From: Tom Errico <thomas.errico@tylin.com>
To: Shukria Wiar <SHUKRIAW@portlandmaine.gov>
CC: David Margolis-Pineo <DMP@portlandmaine.gov>, Katherine Earley <KAS@portlandmaine.gov>, Jeff Tarling <JST@portlandmaine.gov>, "JeremiahBartlett" <JBartlett@portlandmaine.gov>
Date: 5/20/2015 5:06 PM
Subject: 16 Middle Street and 185 Fore Street - Final Traffic Comments

Shukria - I have reviewed project information and the following is a status update of my February 27, 2015 comments and represents my final comments.

DRAWN: CDD	DATE: MAY 2014
DESIGNED: JAL	SCALE: 1" = 10'
CHECKED: JAL	JOB NO. SP-M150
FILE NAME: SP-M150-SITE LAYOUT	
SHEET	C-2.3

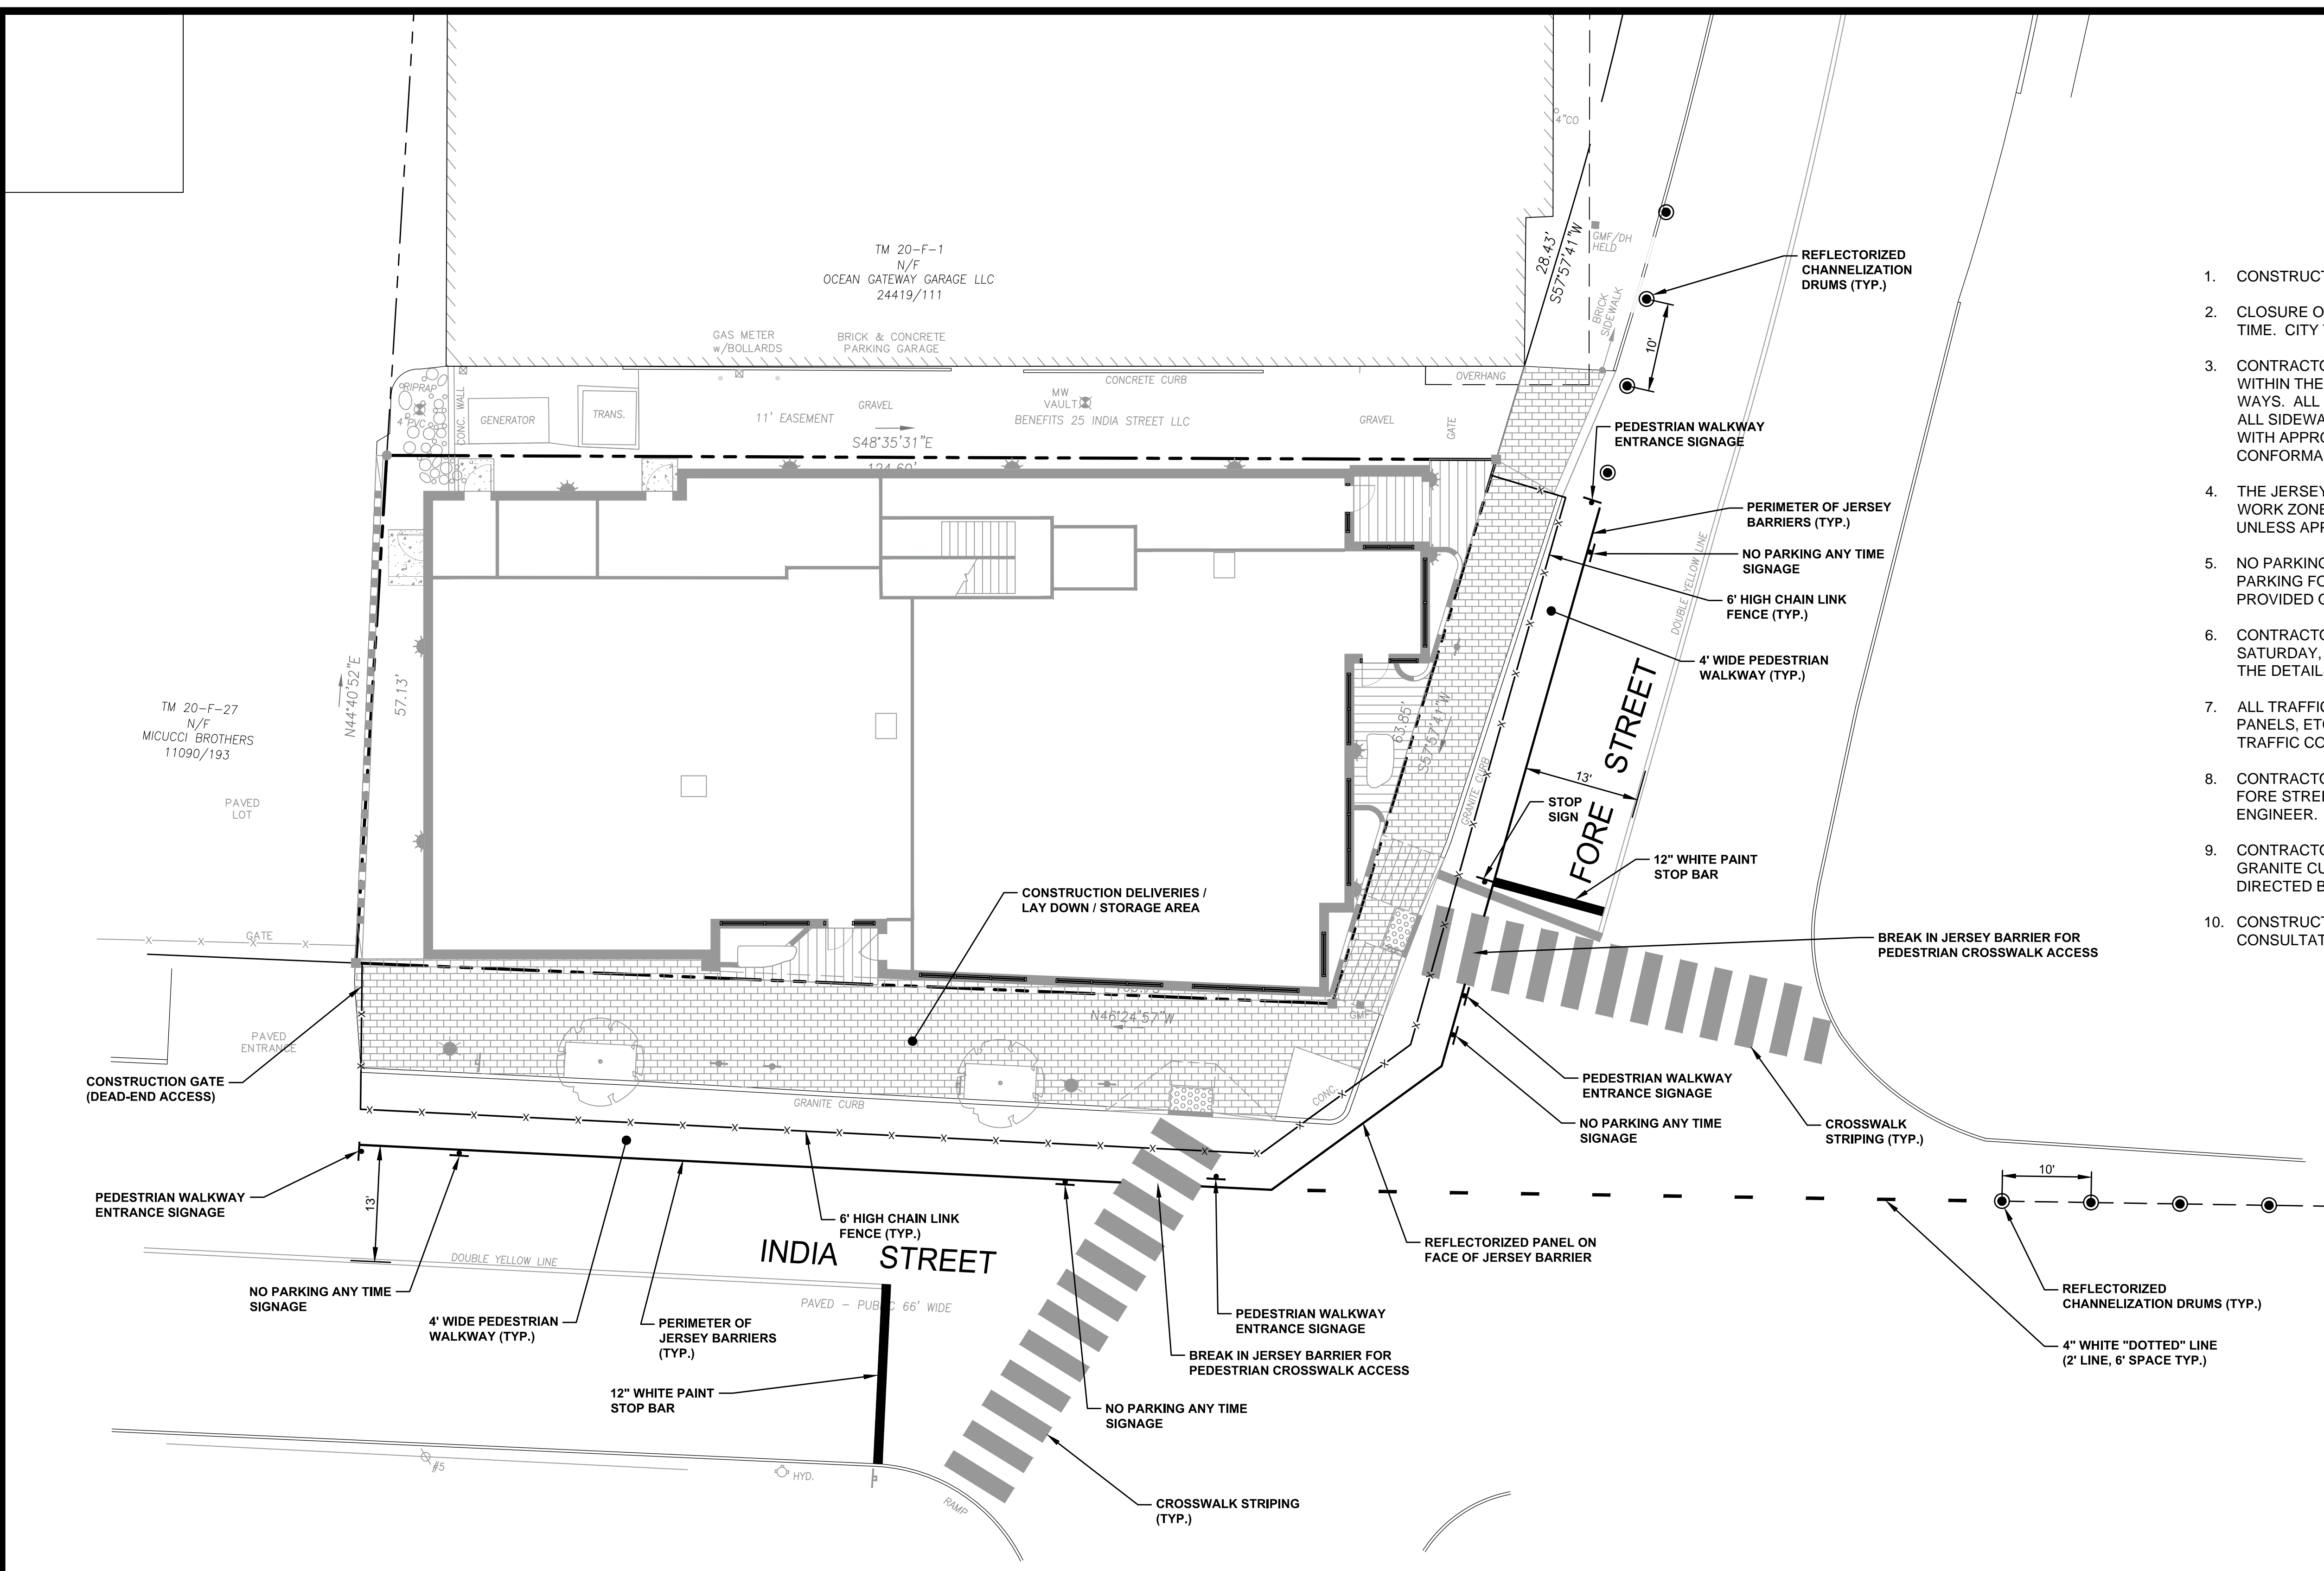
· Greater detail is required for the Construction Management Plan. Specific details on how pedestrian and roadway conditions will be managed during construction.
Status: The construction management plan for 18 Middle Street is acceptable. It should be noted that all temporary sidewalk facilities need to be ADA compliant and have MUTCD compliant signage. Additionally, final review and approval of the Middle Street roadway width (22 feet) will be required by DPS staff before construction begins. The applicant is proposing a temporary barrier protected sidewalk for 185 Forest Street. I find the plan to be acceptable with final details of the barrier to be approved by DPS prior to construction. I would also note that the temporary sidewalk must be ADA compliant.

(A) DRIVEWAY APRON LAYOUT
N.T.S.
AS OBTAINED FROM THE CITY OF PORTLAND "TECHNICAL MANUAL"

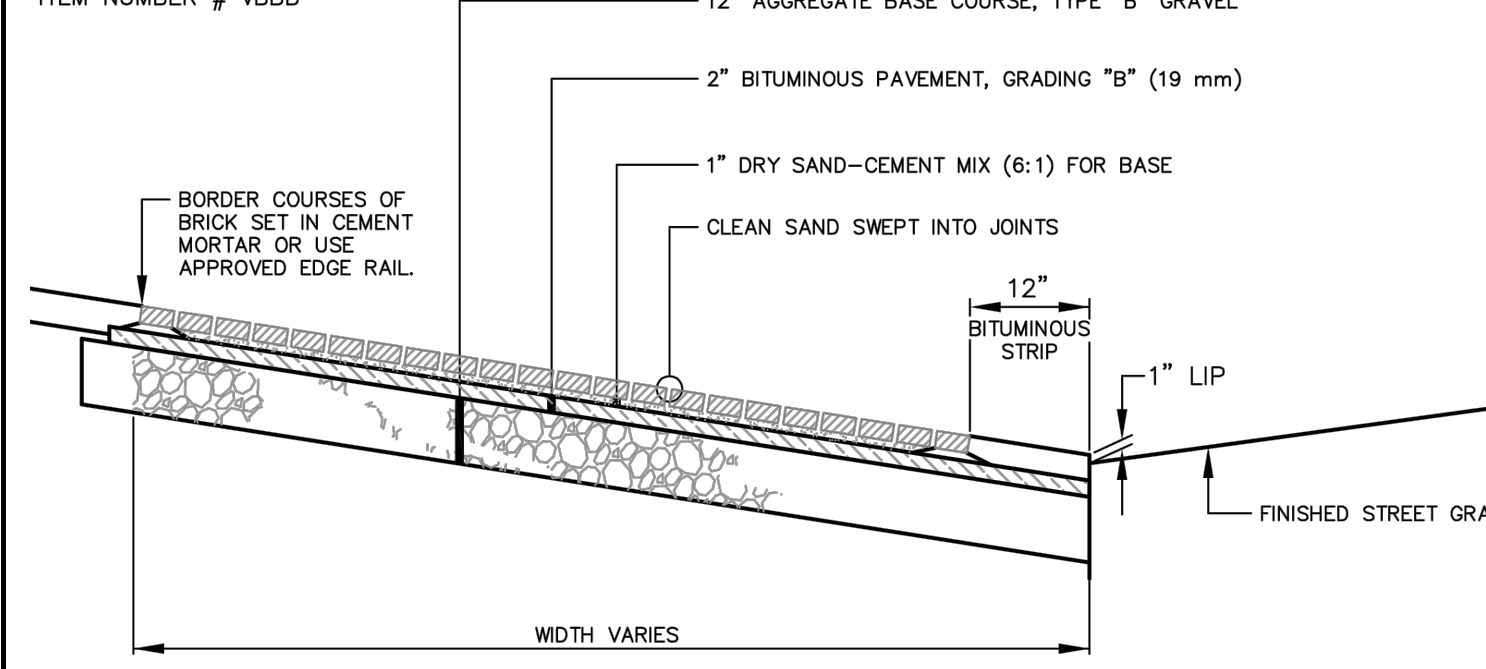
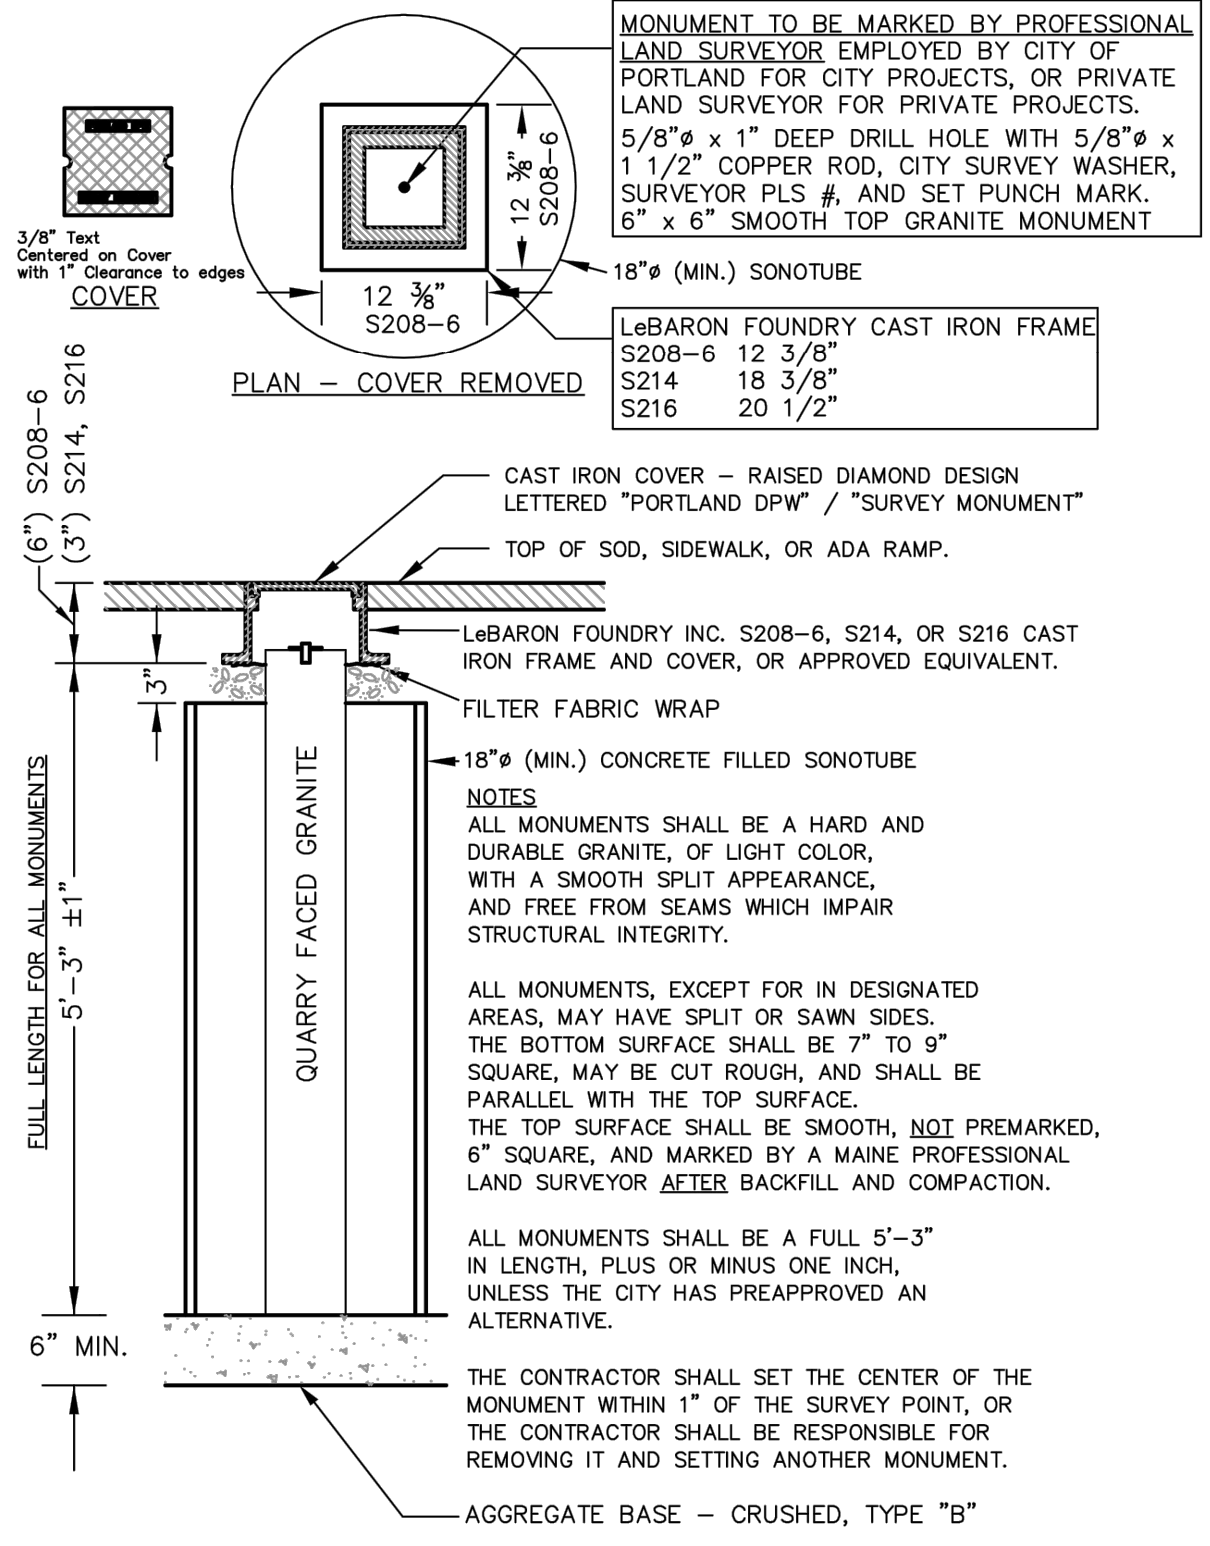
· I would suggest that the driveway apron on Fore Street be designed such that it favors the sidewalk and pedestrian use rather than vehicle movements, which is expected to be minimal.
Status: The applicant has revised the plan and I have no further comment.
